## **GRADING AND EROSION CONTROL PLAN CHECKLIST PPR-21-020**

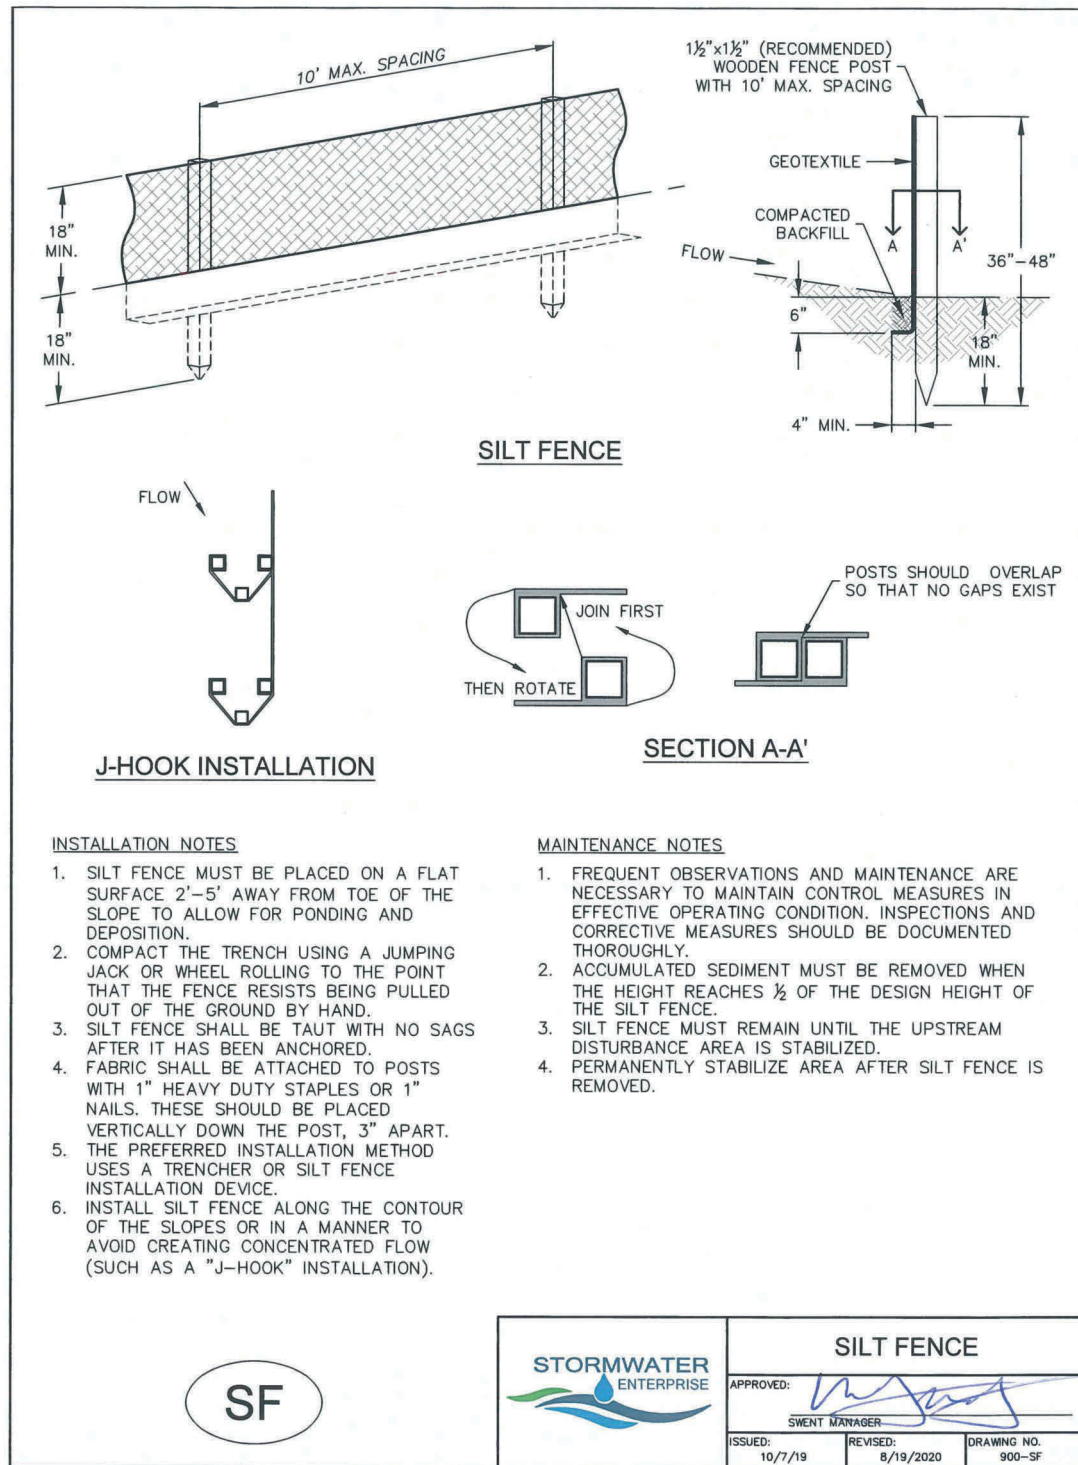
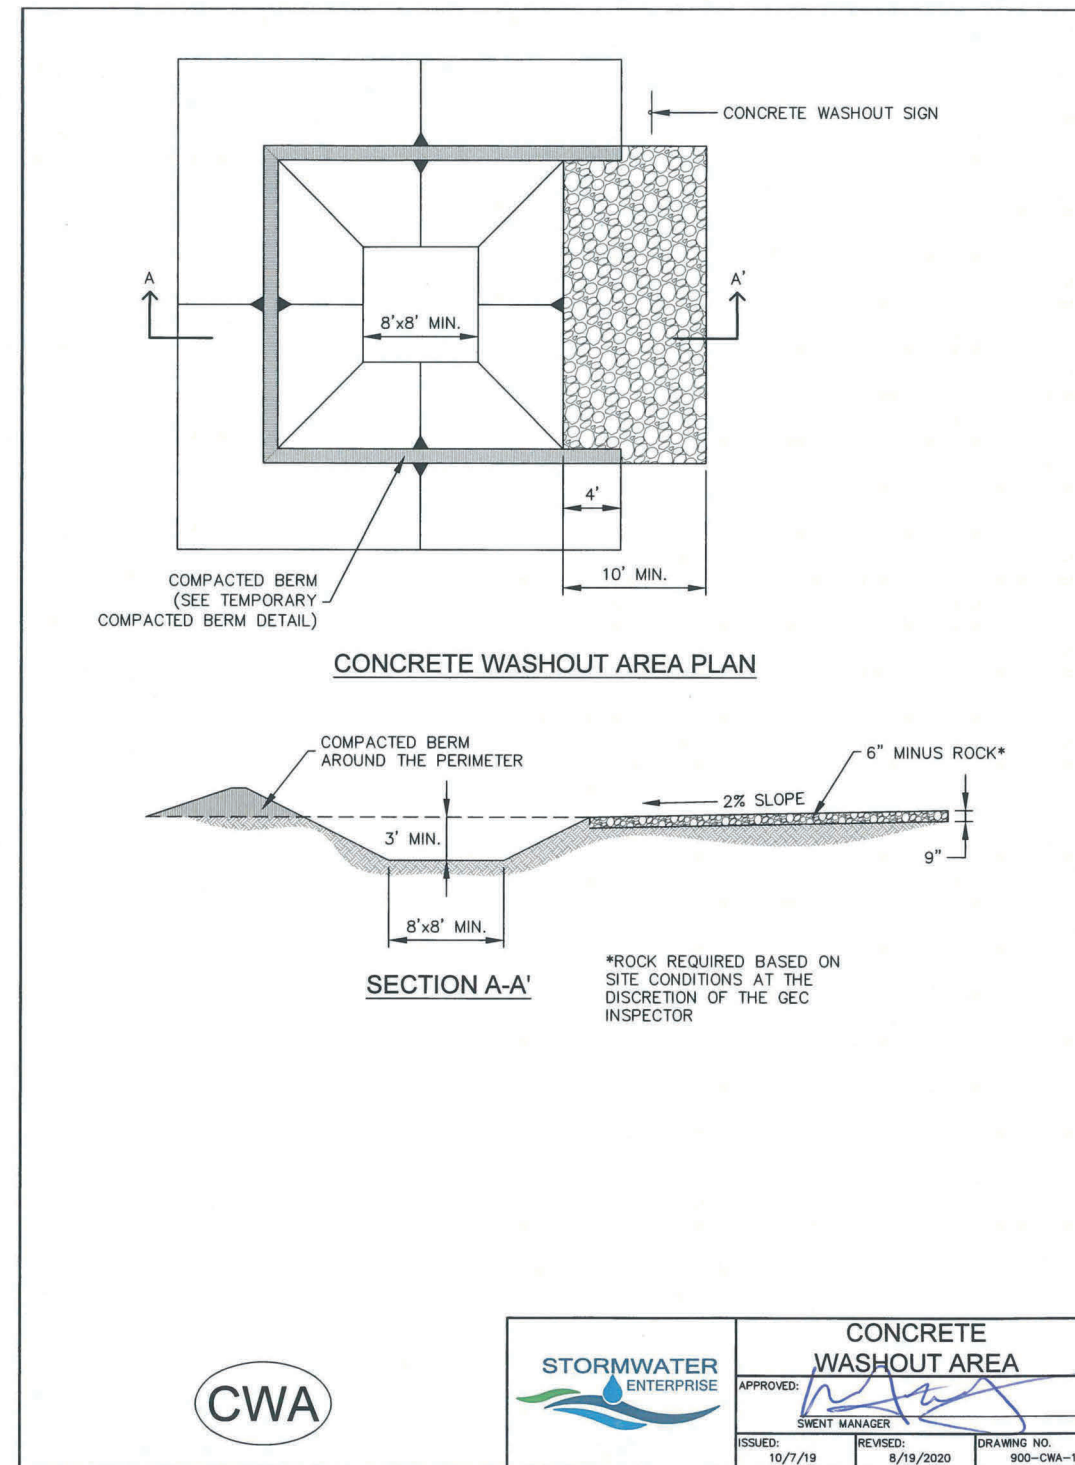
u	Areas used for staging, storage of building materials, soils (stockpiles) or wastes. The use of construction office trailers requires PCD permitting.	X	Y
v	All proposed temporary construction control measures, structural and non-structural. Temporary construction control measures shall be identified by phase of implementation to include "initial," "interim," and "final" or shown on separate phased maps identifying each phase.	X	Y
w	Vehicle tracking provided at all construction entrances/exits. Construction fencing, barricades, and/or signage provided at access points not to be used for construction.	X	Y
x	Temporary sediment ponds provided for disturbed drainage areas greater than 1 acre.	N/A	N/A
y	Dewatering operations to include locations of diversion, pump and discharge(s) as anticipated at time of design.	N/A	N/A
z	All proposed temporary construction control measure details. Custom or other jurisdiction's details used must meet or exceed EPC standards. <small>See comment on Sht C16</small>	X	Y
